27 May 2014

Re: Banksmeadow Waste Transfer Terminal (SSD 5855) – 14 Beauchamp Road & 34 - 36 McPherson Street, Banksmeadow

Daniela Vujic
Senior Planning and Environmental Manager
NSW Ports

Figure 20 Left - Layout of Beauchamp Road/ Perry Street/ Site Access intersection tested in *build with no other development case* (Section 3.4); Right – Revised layout of intersection as tested in Section 3.5.

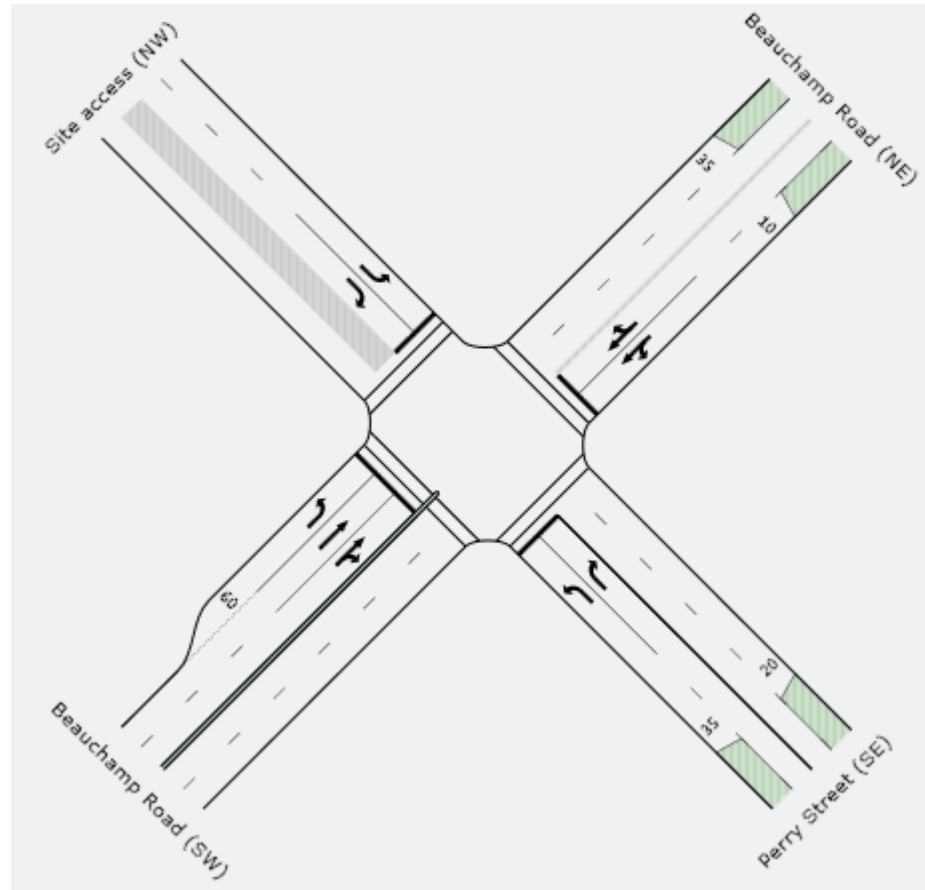
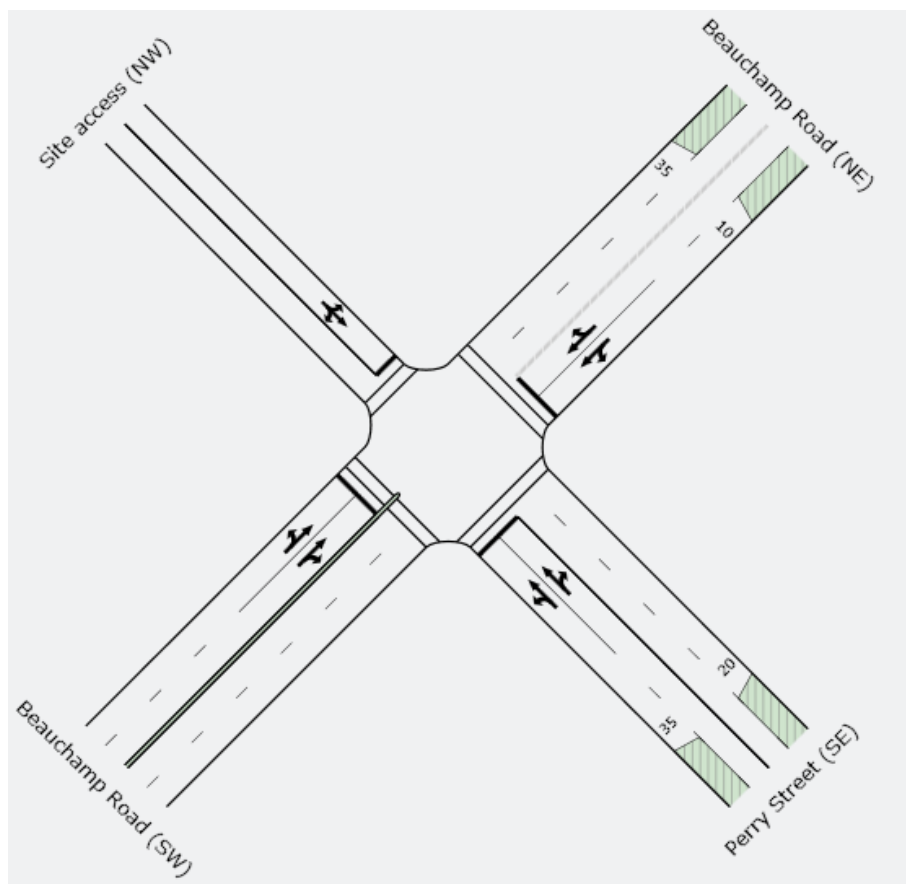
Notwithstanding the above, NSW Ports is supportive of mitigation measures being implemented in order to maintain the levels of service at intersections likely to be impacted by the proposed development. To this effect, NSW Ports supports the installation of a left-hand turn slip lane on the southern approach from Beauchamp Road and the prohibition of through traffic between the site and Perry Street.

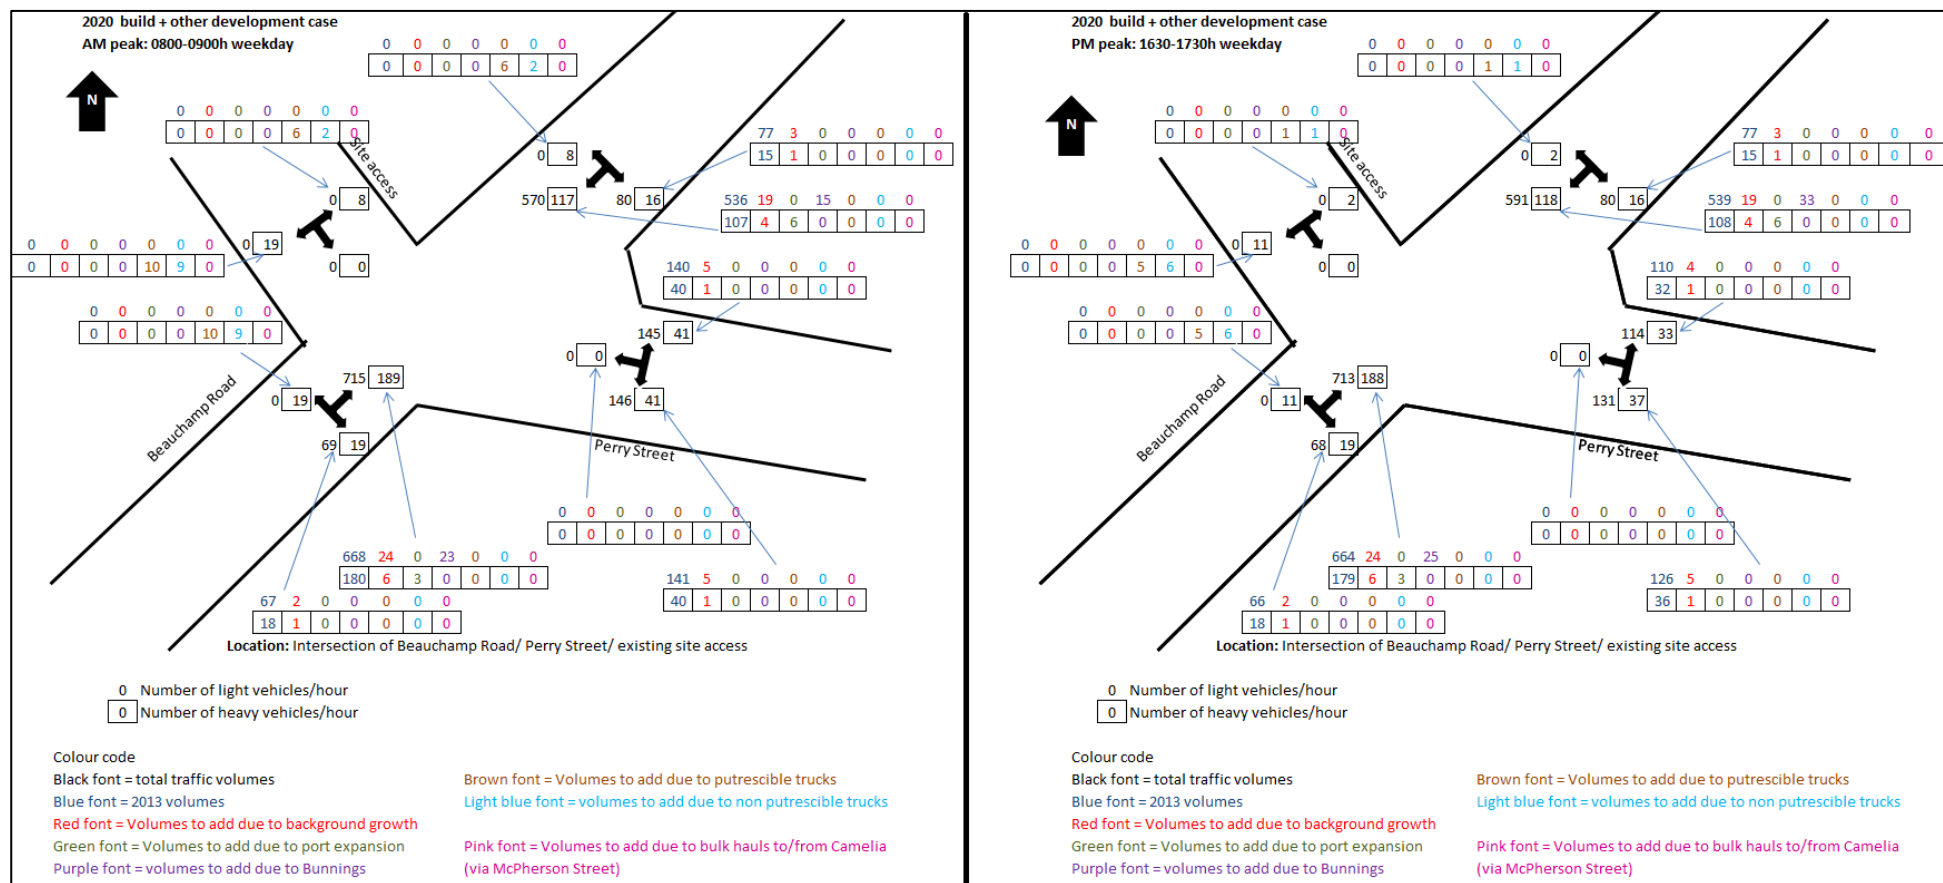
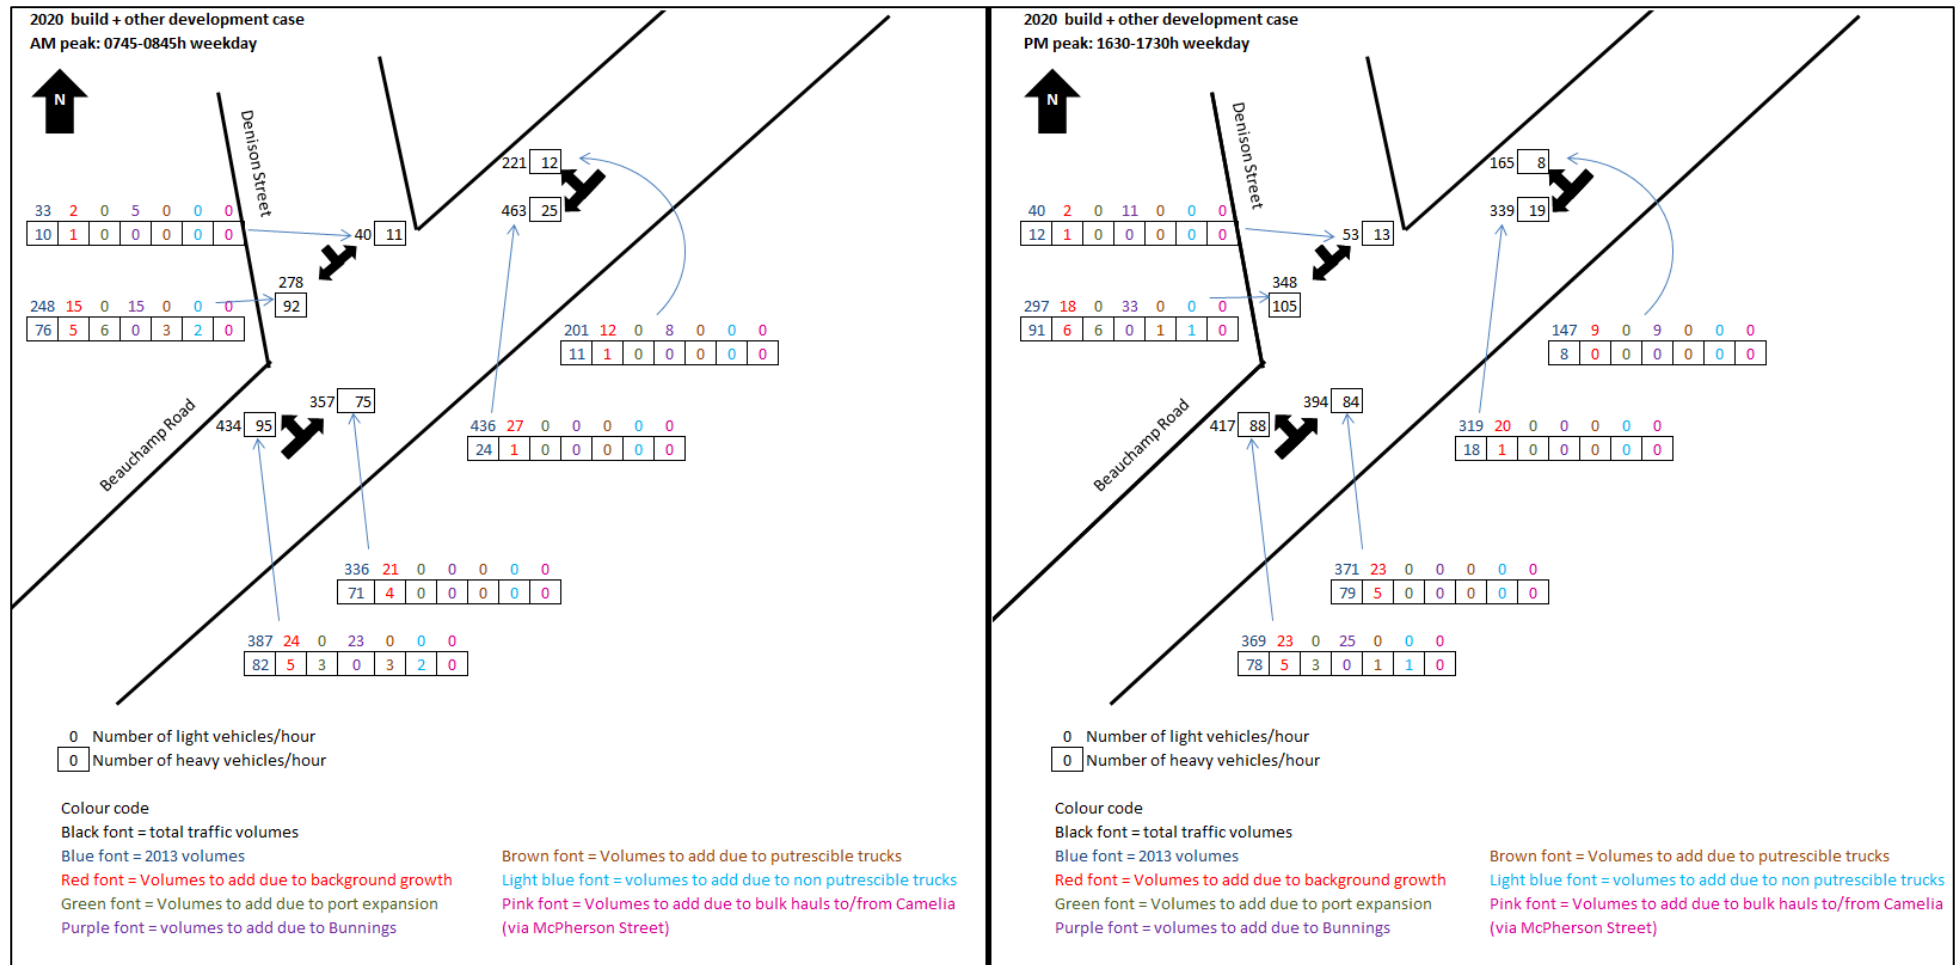
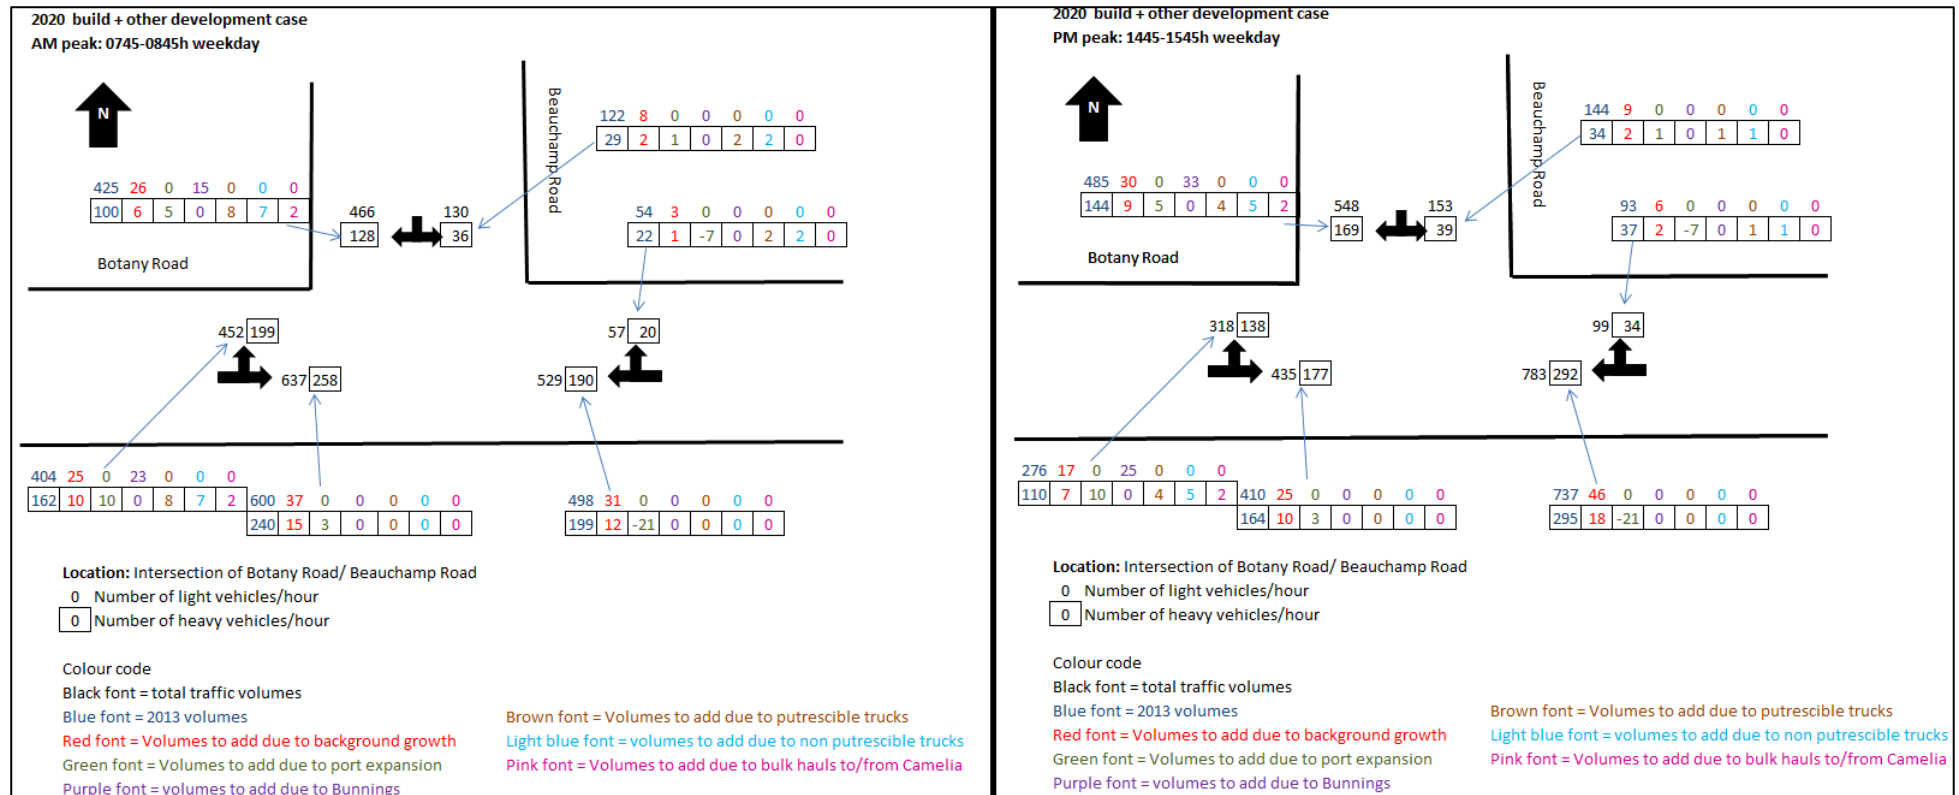
The Traffic and Access Impact Assessment (Appendix H of the EIS) has considered the cumulative traffic impacts from the Port Botany Expansion (PBE) project when assessing the forecasted traffic related impacts from the proposed development however, the assessment assumed a 30% rail modal share of container trade by 2020 from the Port Botany Port Precinct. Based on this rail modal share assumption, the predicted vehicle traffic growth from Port Botany in the AM and PM peak at the three intersections assessed is lower than the worst case assessed in the PBE EIS.

In 2002 an EIS was prepared for the PBE project. The PBE EIS included an assessment of the likely traffic movements to be generated by the PBE Project and the Port Botany Port Precinct as a whole by 2021 and assumed, as part of the traffic impact assessment (Appendix P of the PBE EIS), a 20% rail modal share of container trade as the worst case scenario. The PBE traffic assessment predicted that there would be an increase of 31 vehicles by 2021 during the AM peak at the Beauchamp Road / Botany Road intersection as a result of the PBE project becoming operational. However, the traffic impact assessment for the proposed Waste Transfer Terminal has assumed a 30% rail modal share and therefore a reduction in the traffic contribution of the Port Precinct by 2020 (refer to Table 8-37 of the Waste Transfer Terminal EIS).

NSW Ports requests that the cumulative traffic impact assessment for the proposed development be revised to consider the impact of a 20% rail modal share and whether further mitigation measures would be required to deliver this project.
